# (Metrolink-Estuary to Charlemont

## Estuary Court Residents Association

### Submission 2

## Long- and Short-Term Impact of Proposed Metrolink Through Estuary Court

Project	Drawing Title	Drawing Status
Estuary - Seatown Landscape Layout Preliminary Design Issue		S4
Drawing N°	ML1-JAI-ARL-SC01_XX-DR-Y-00001	
Scales Original Size A1	1:1000	Sheet 1 of 3

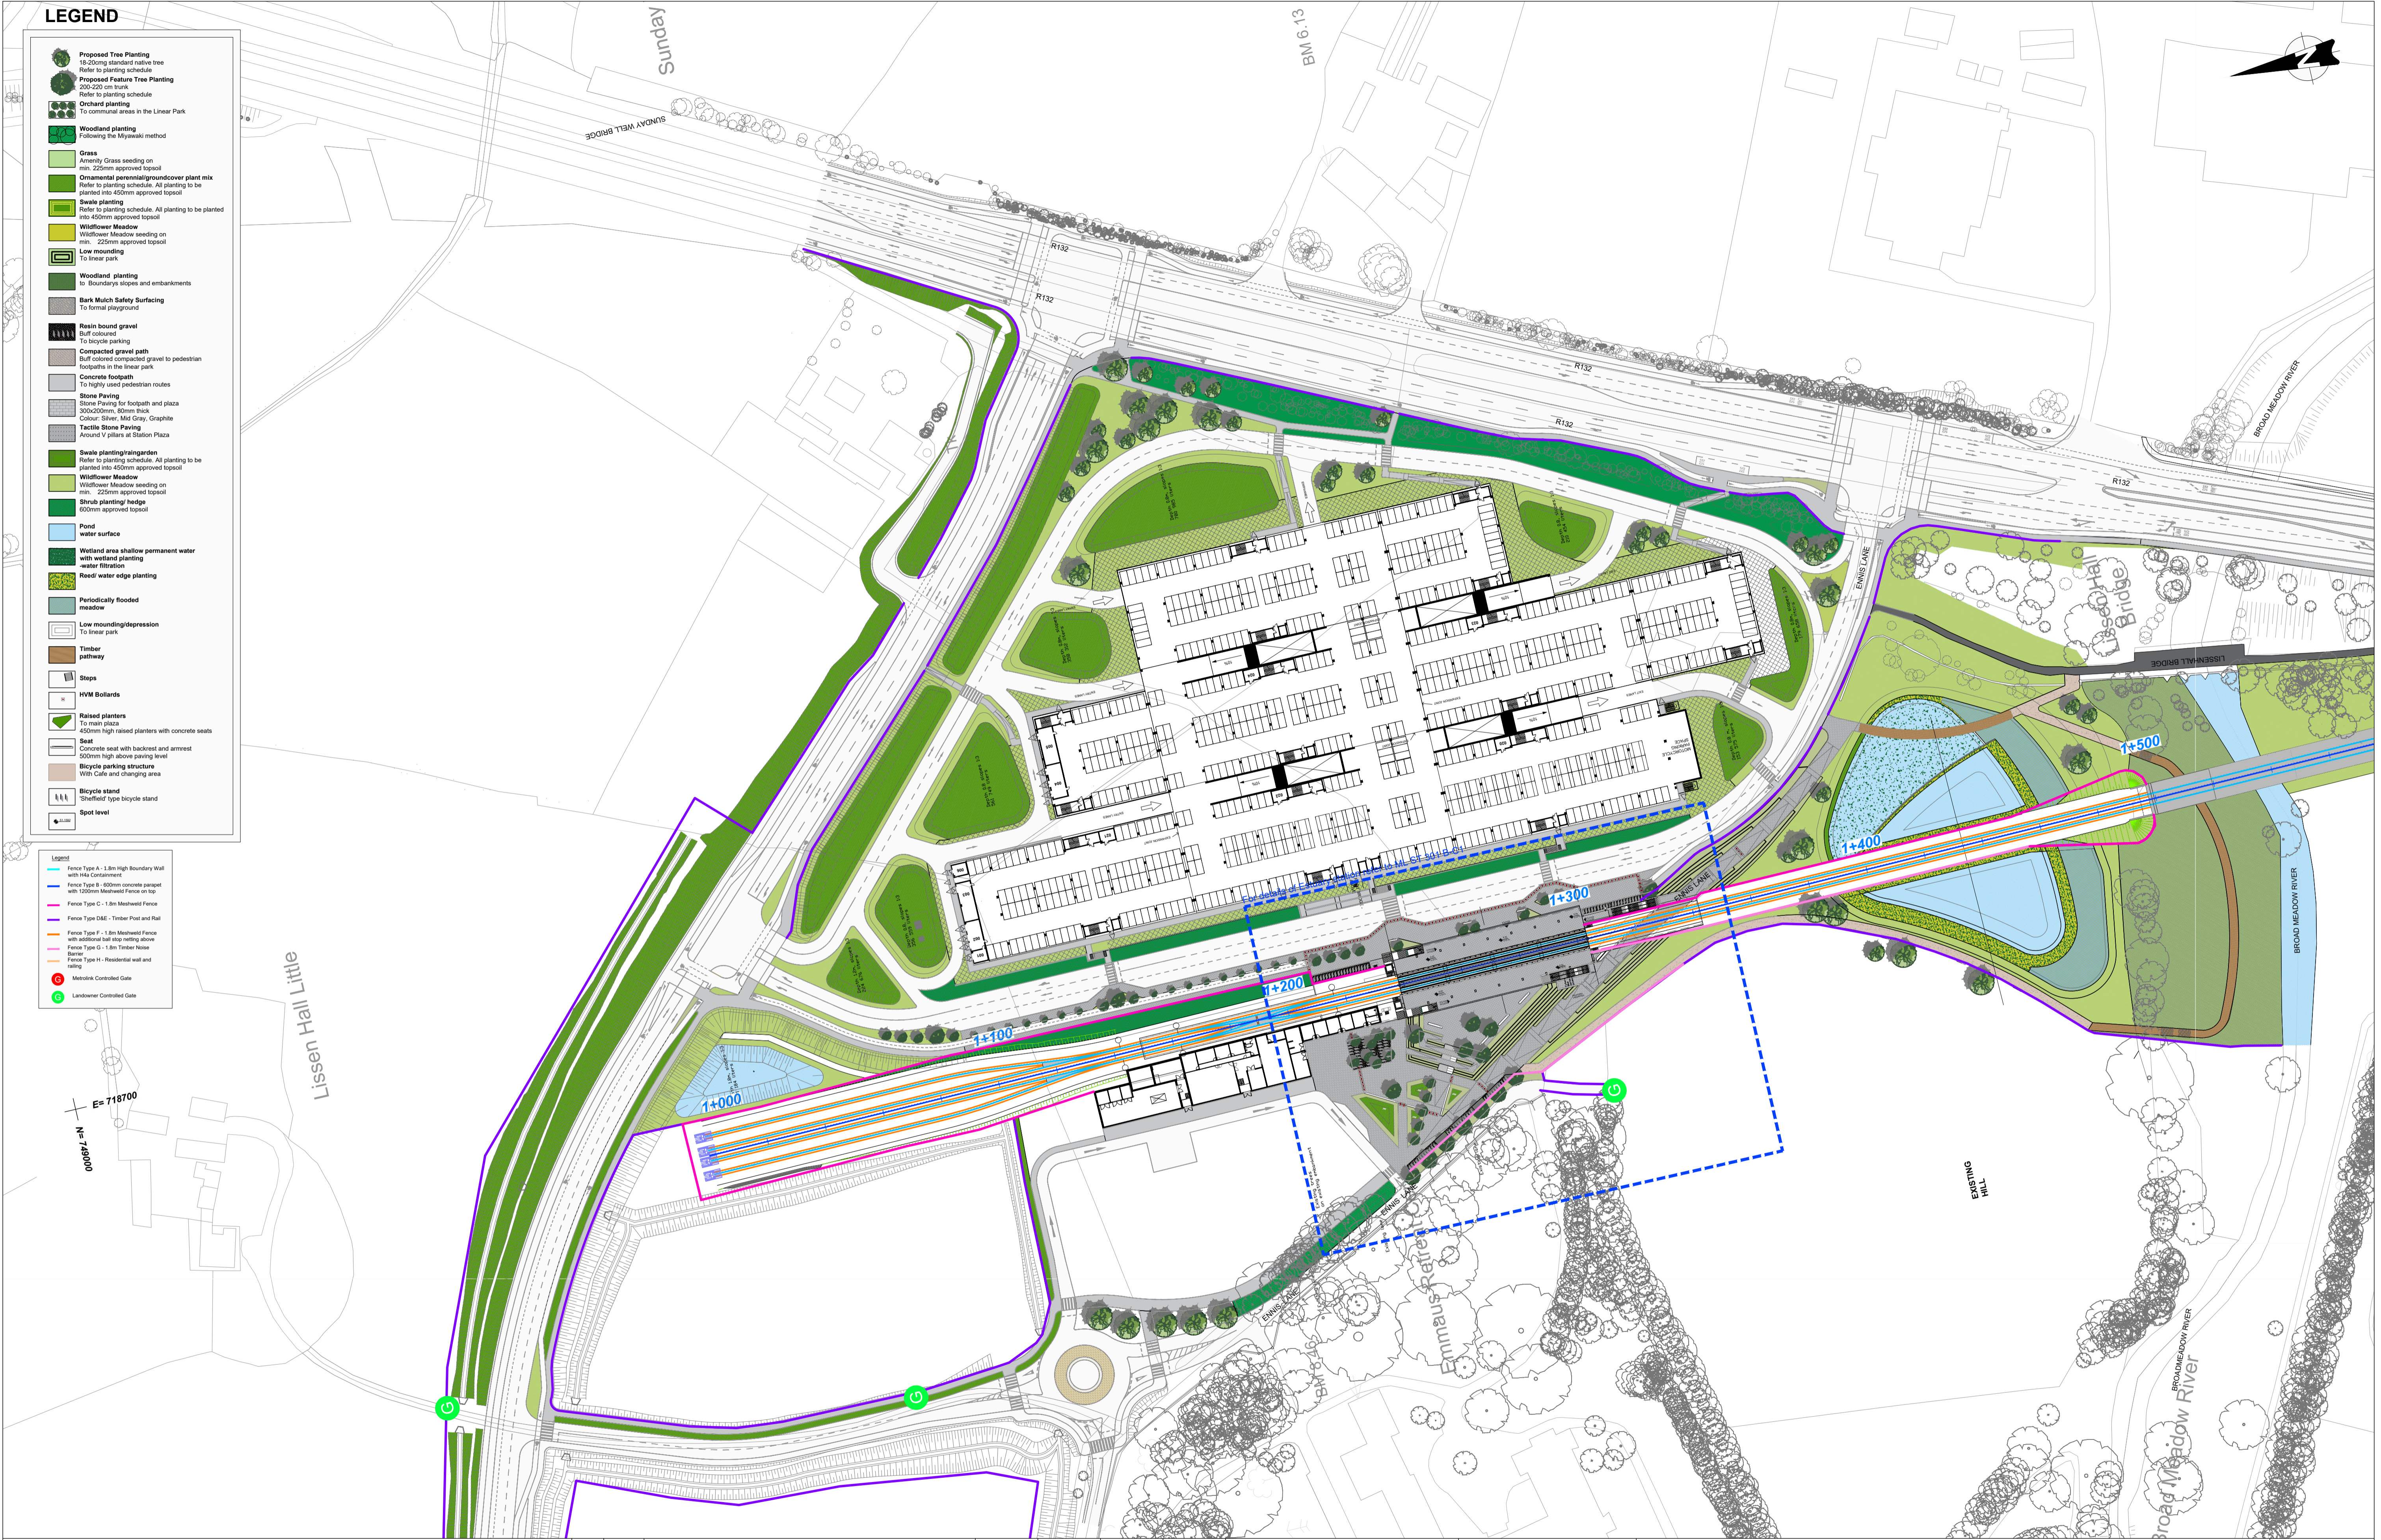
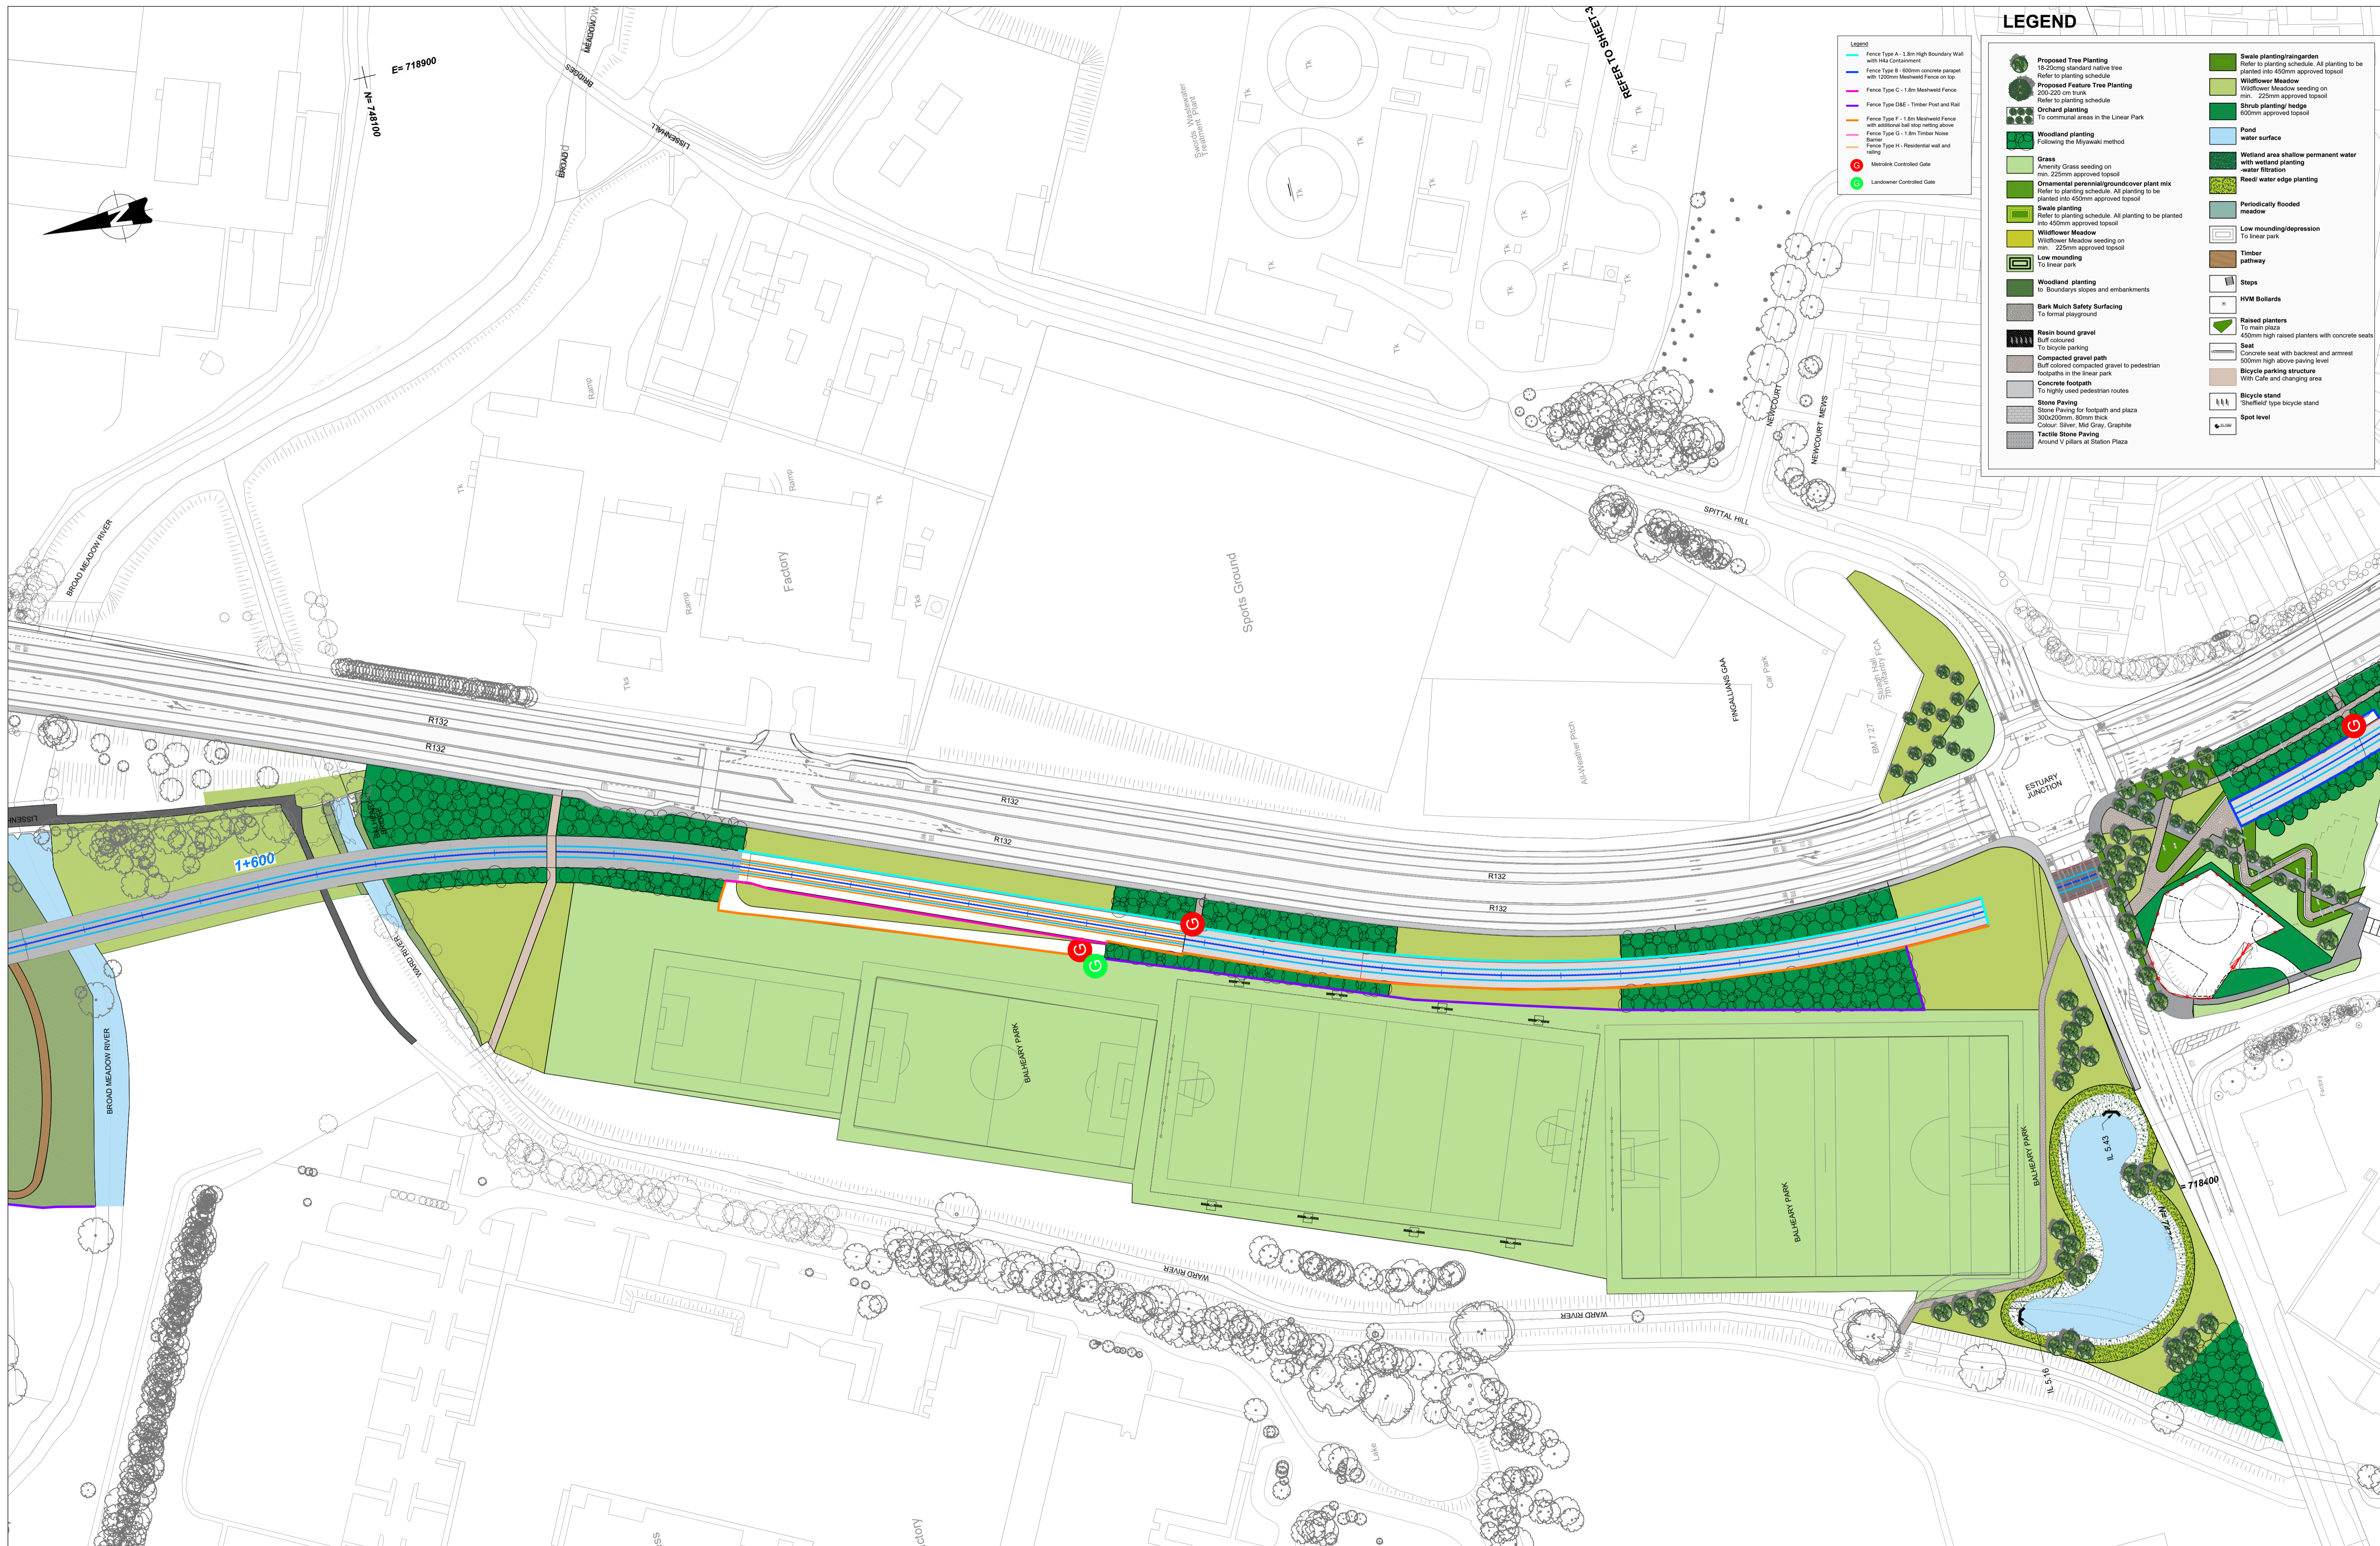
To make matters even worse, when the construction works are complete, the TII do not plan to give us back what we currently have. They have proposed re-developing our open greens into a linear park to run up along the R132. The section of park at Estuary Court will have very limited open green space and will be replaced with planting and paths running through it.

Q To follow on from your new updated plans which were only update, What guarantee do we have this will not be reinstated to your original plan at a later point as still in your submission.

The TII originally proposed not to reinstate our boundary wall after the Metrolink construction is complete. They had plans to open up our estate to the public and our green spaces would become part of a public linear park. We have engaged with TII over the last two years and one of our main concerns was the replacement of the wall. We tried our best to express the importance of the wall to our estate and even insisted on having our last meeting on site (dated 4/4/2022) to illustrate this. During this time, the TII put forward a number of proposals however, they all fell short of what we currently have and what will meet the needs of the residents. The proposed plan in the Rail Order now includes for a boundary wall (wall type H) and appears to be in a similar location to our existing wall (to be confirmed). However, the wall also includes for four access gaps in the wall (Fig 3.2 of the submission). This poses a security risk for both our houses and for our and the safety of our children playing on the green. The existing boundary

wall is a key component that makes our estate safe and secure while also acting as a noise barrier and along with the mature landscaping aesthetically enhancing our estate. A wall with access points, is not secure for children. The main reason the wall was built by the council in the first place was for the safety of children and this is still relevant today. The residents do not want any access points in it. We believe it is a reasonable request for the wall to be reinstated end to end, like for like. We note the General Arrangement drawing for this area(Fig 3.5 of the submission) in the Rail Order specifies for the existing wall to be replaced.

Q changed in the new up to date plans just submitted.

The nature of the proposed planting is biodiverse and will mature to provide a much more valuable, connected landscape than is currently the case. The proposed tree planting will be much more appropriately scaled to the adjacent residential open spaces than the existing predominant tall roadside trees. This proposed section of the R132 extensive landscaping, which is being included as an integral part of the proposed Project within this Local Landscape Character Area (LLCA), will beneficially transform the interconnectedness of this area, across and along the road and with the range of local communities and facilities around the eastern side of Swords. This is particularly so for pedestrians and cyclists. It will represent a significant positive effect of the proposed Project in respect of its broader landscape context and in terms of social and cultural amenity for the town of Swords and its environs. It also represents a major enhancement of the existing landscape condition.
